DARLINGTON POINT

Review of FBA Assessment

November 2018

Report No. 4689/R01/V3/FINAL

MZ7b - PG / Moderate to Good - Moderate - Outside Array

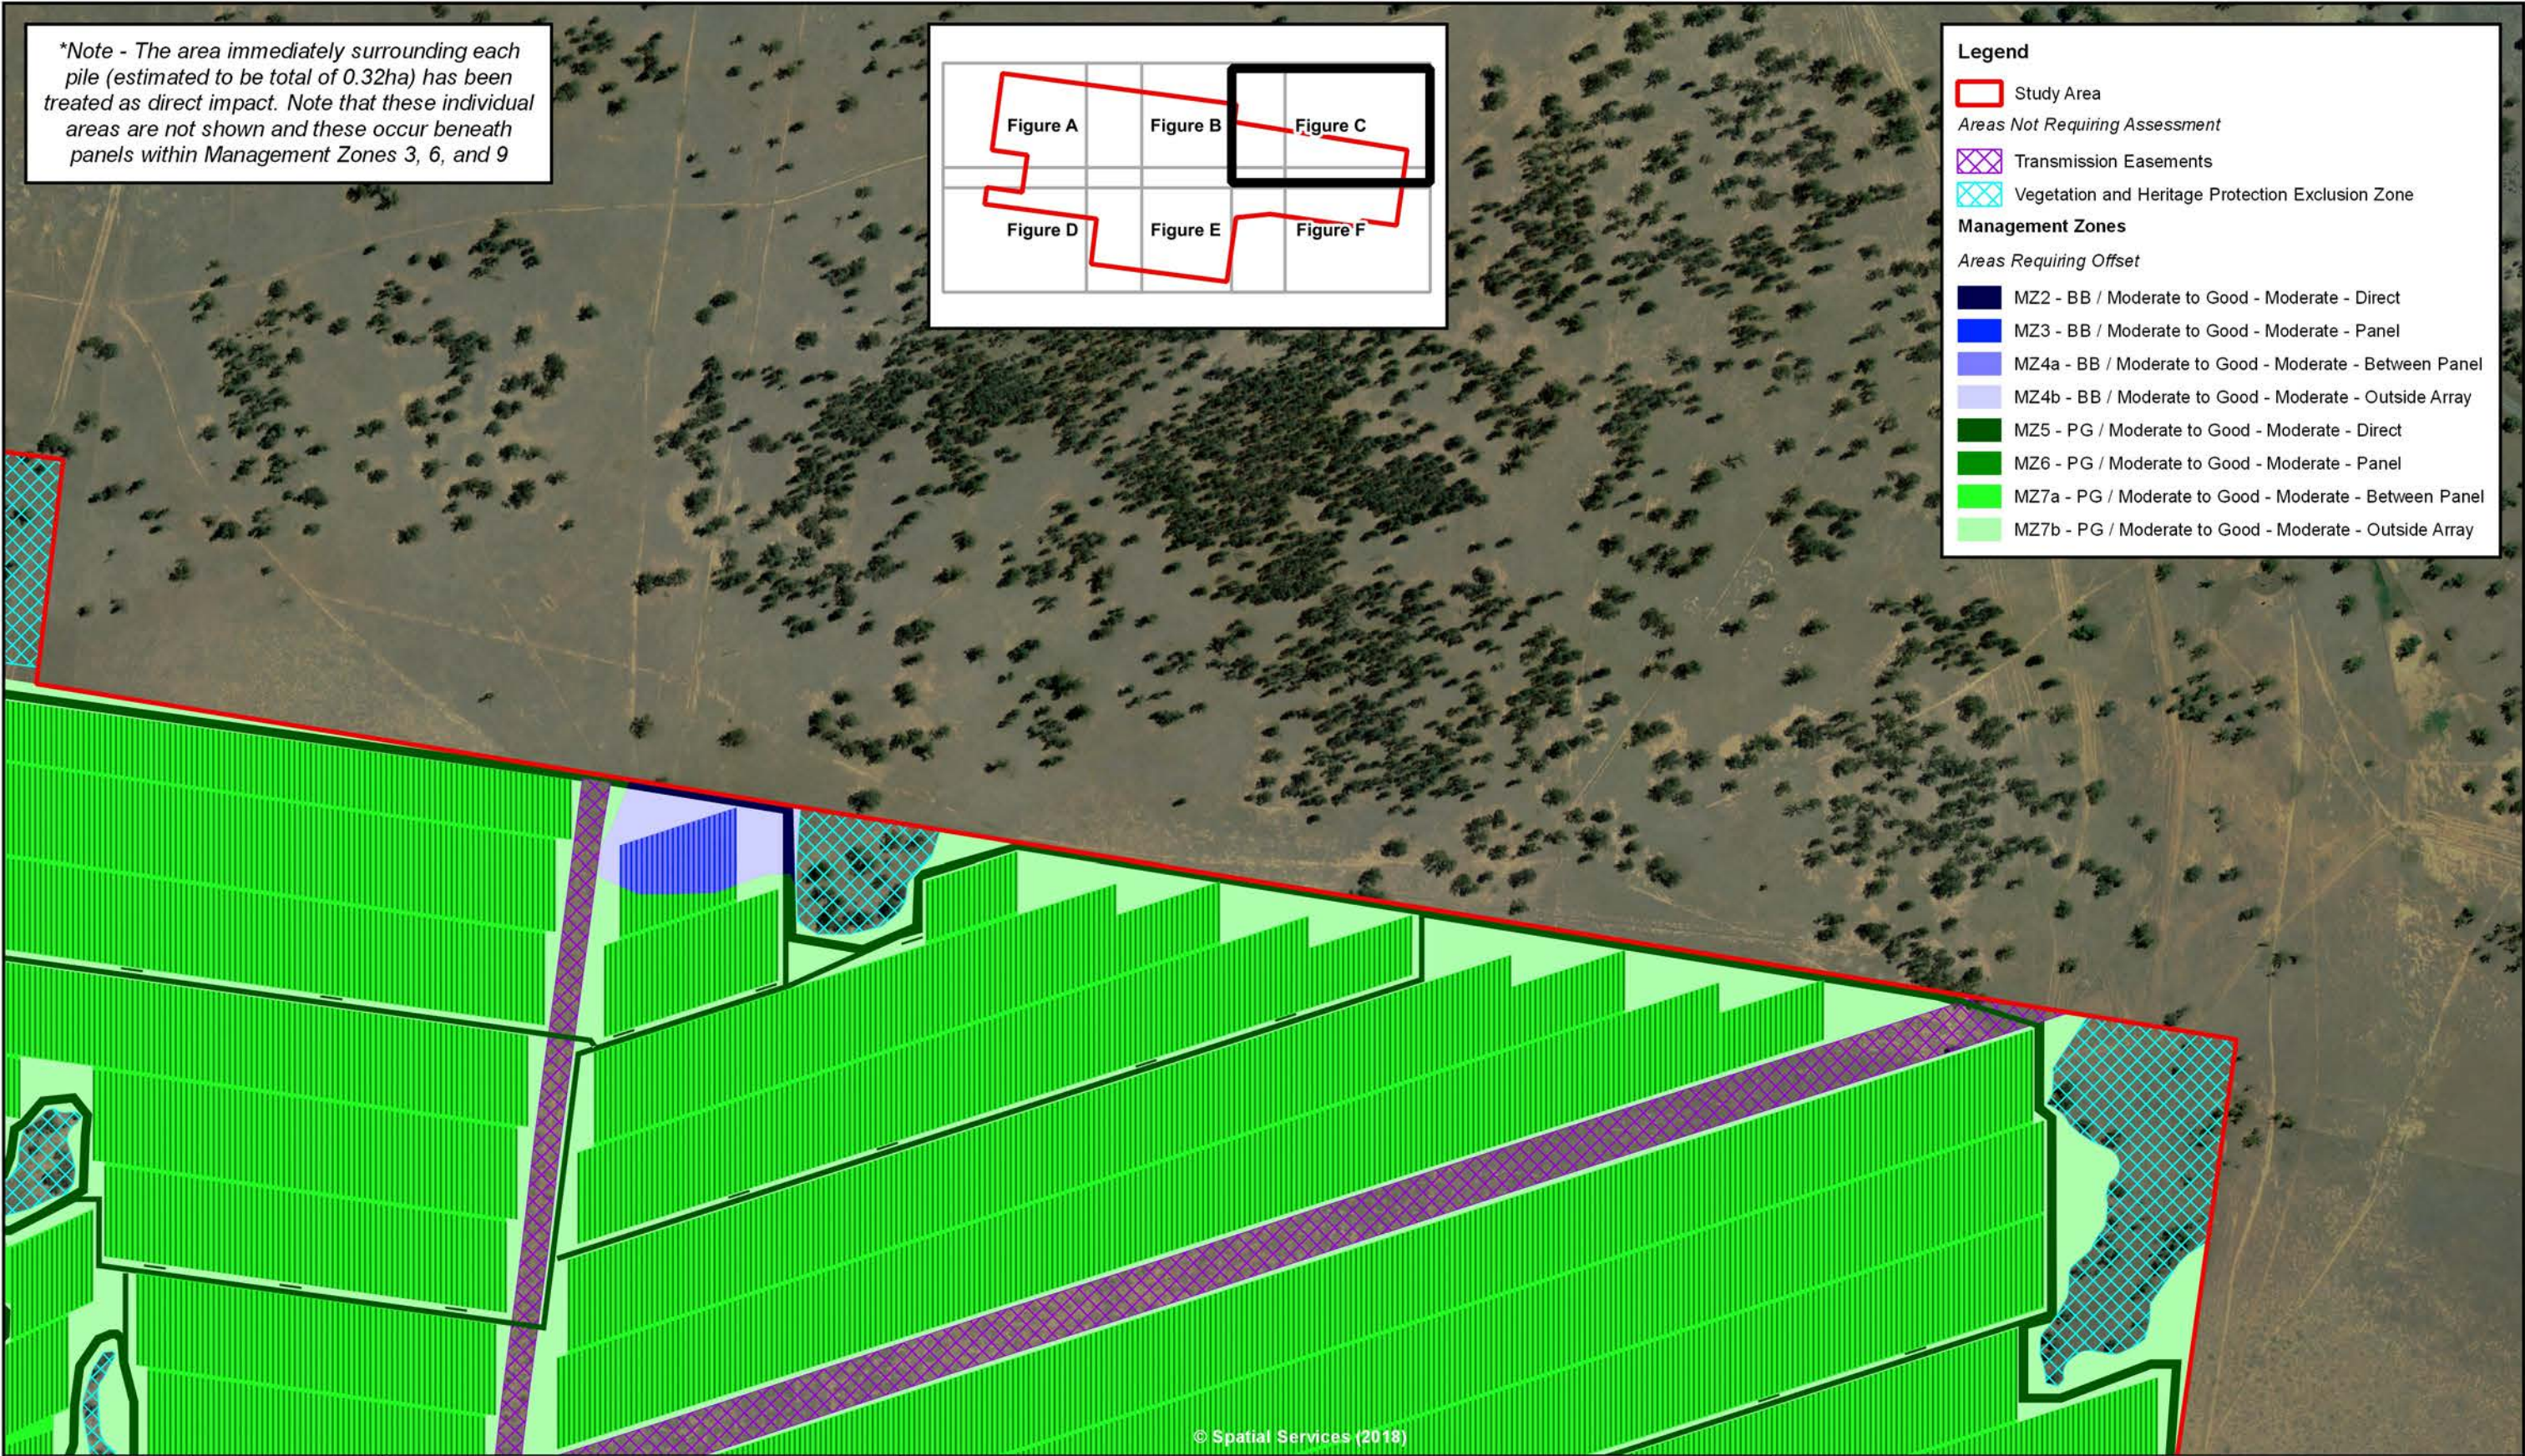
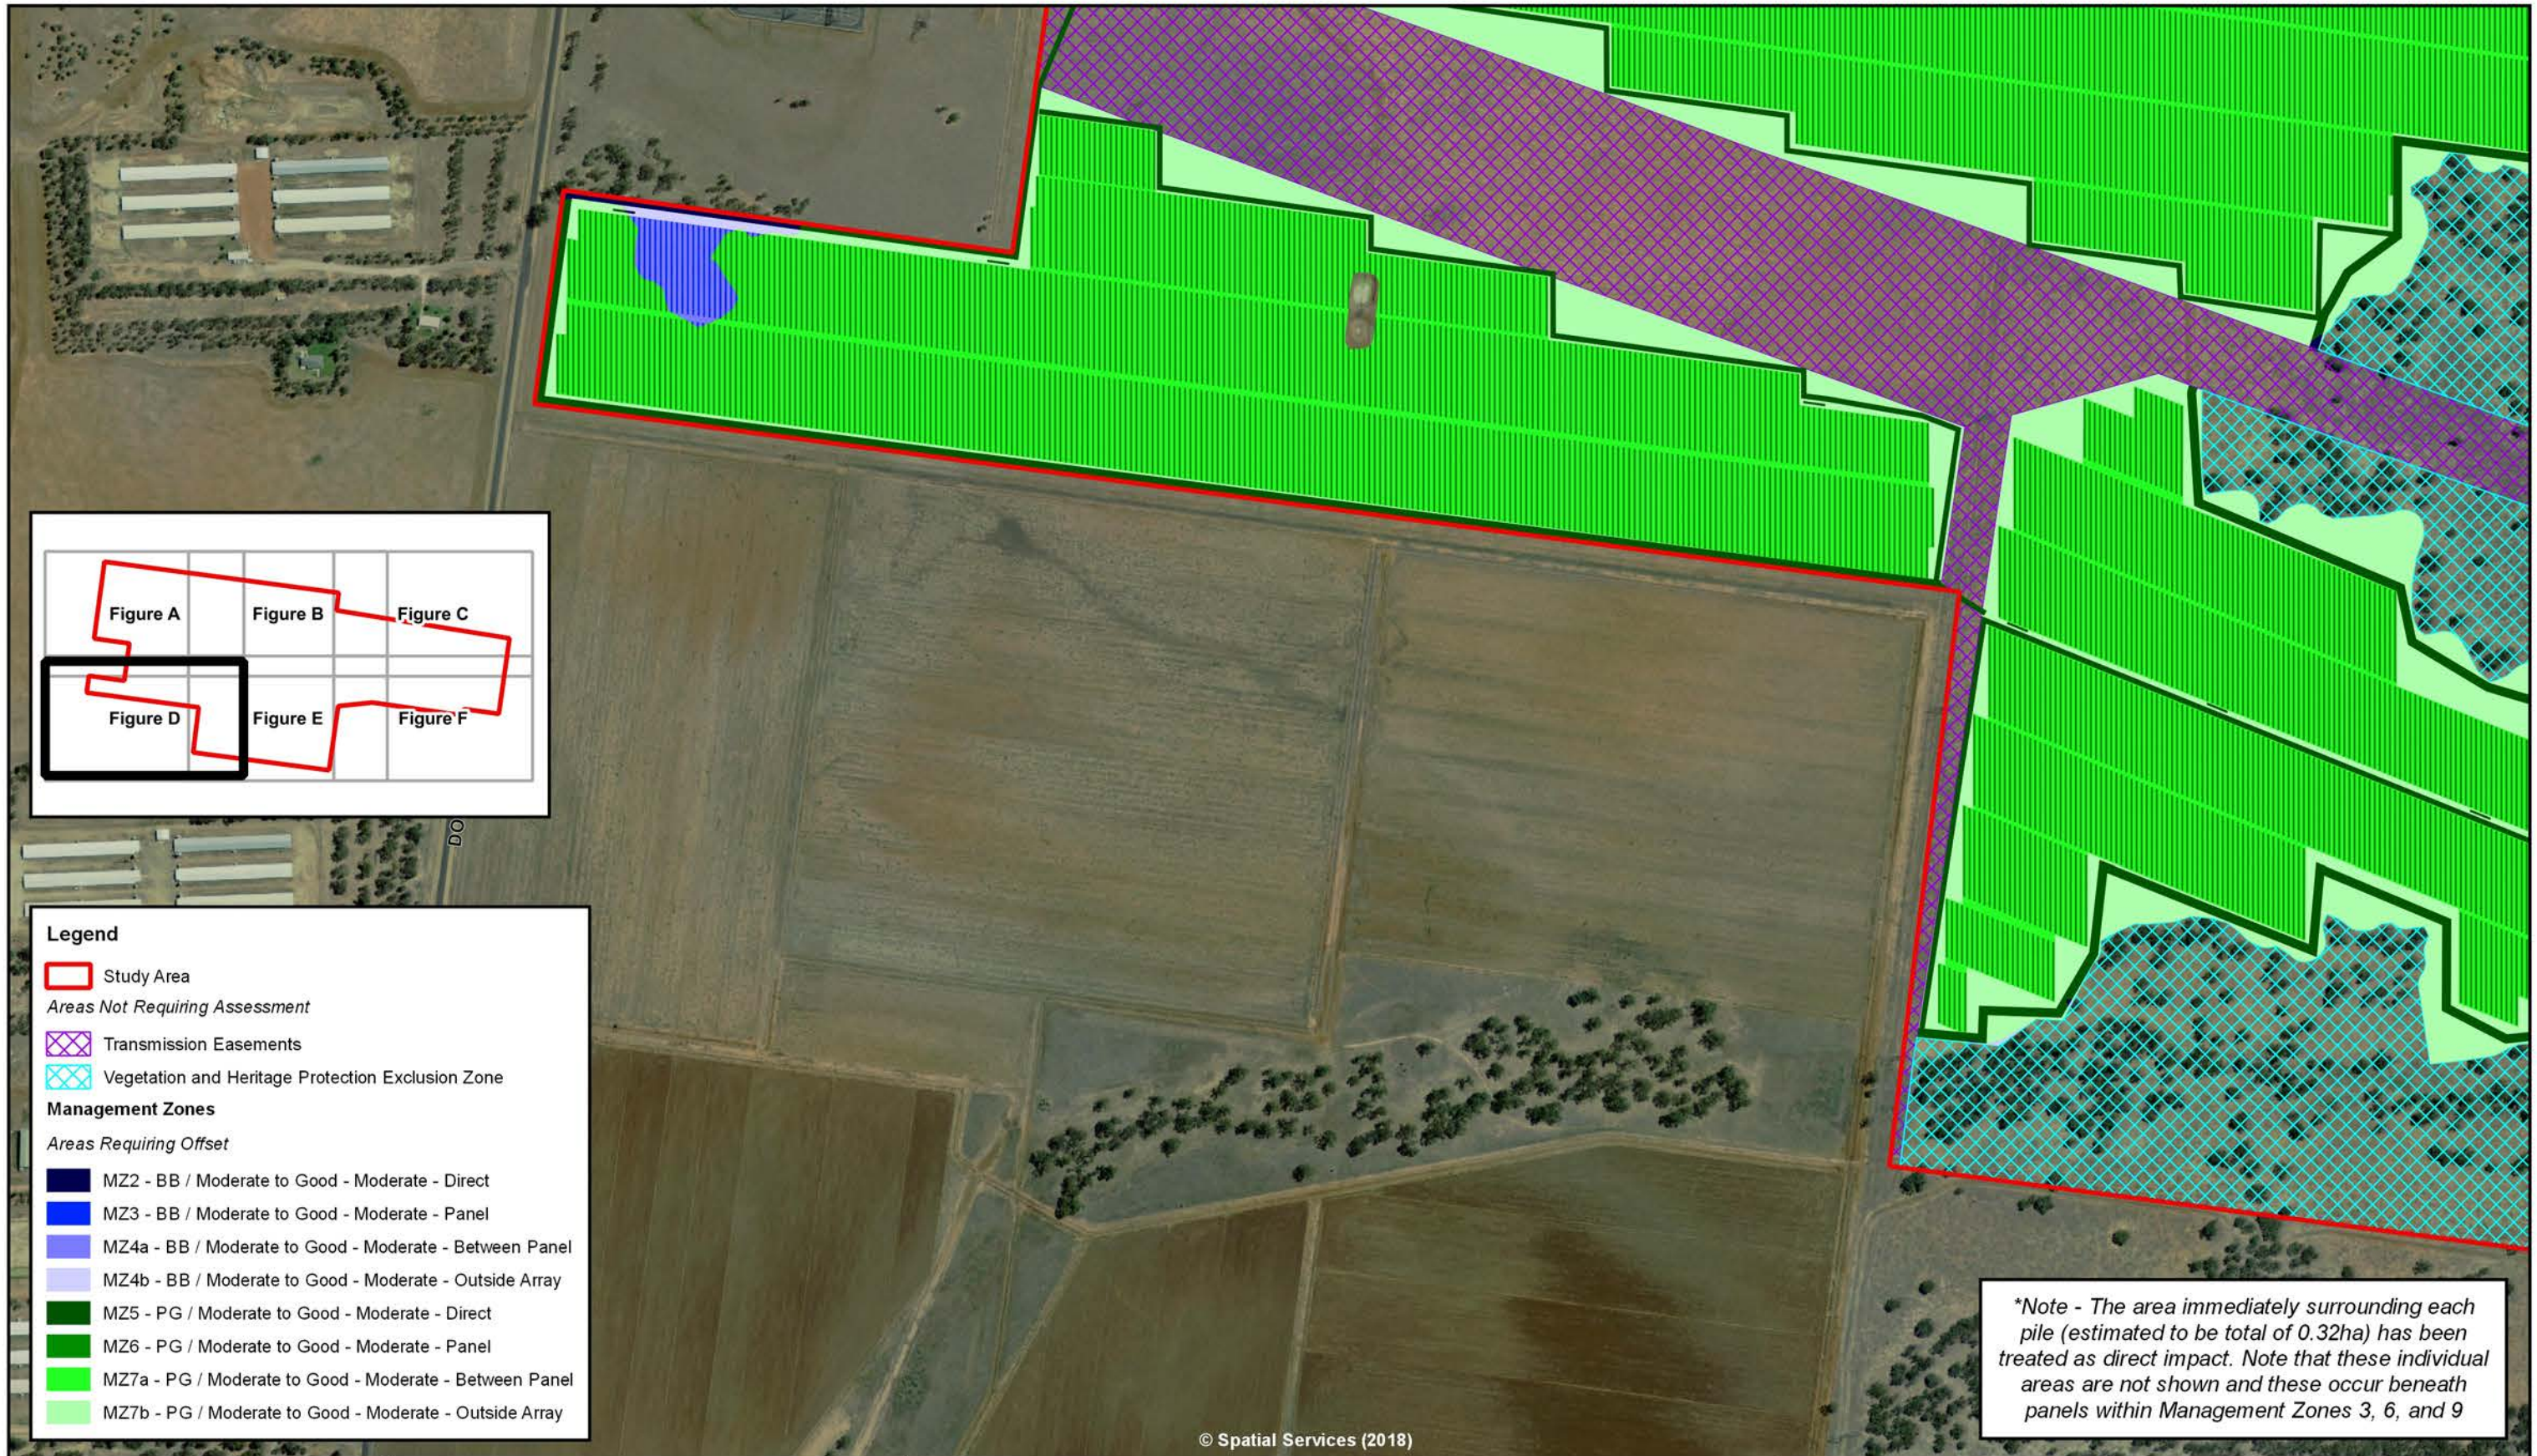
- B. The ‘Non-panel’ assessment zone is confusing because it includes grassland ‘between panel rows’ and ‘outside array’. These areas have different potential impacts. A map of management zones, in accordance with standard FBA methodology, would assist in understanding how biometric site score values have been apportioned [this is a reasonable request].

1. **The proponent should provide a map of management zones and indication of how future site score values have been apportioned across vegetation zones.**
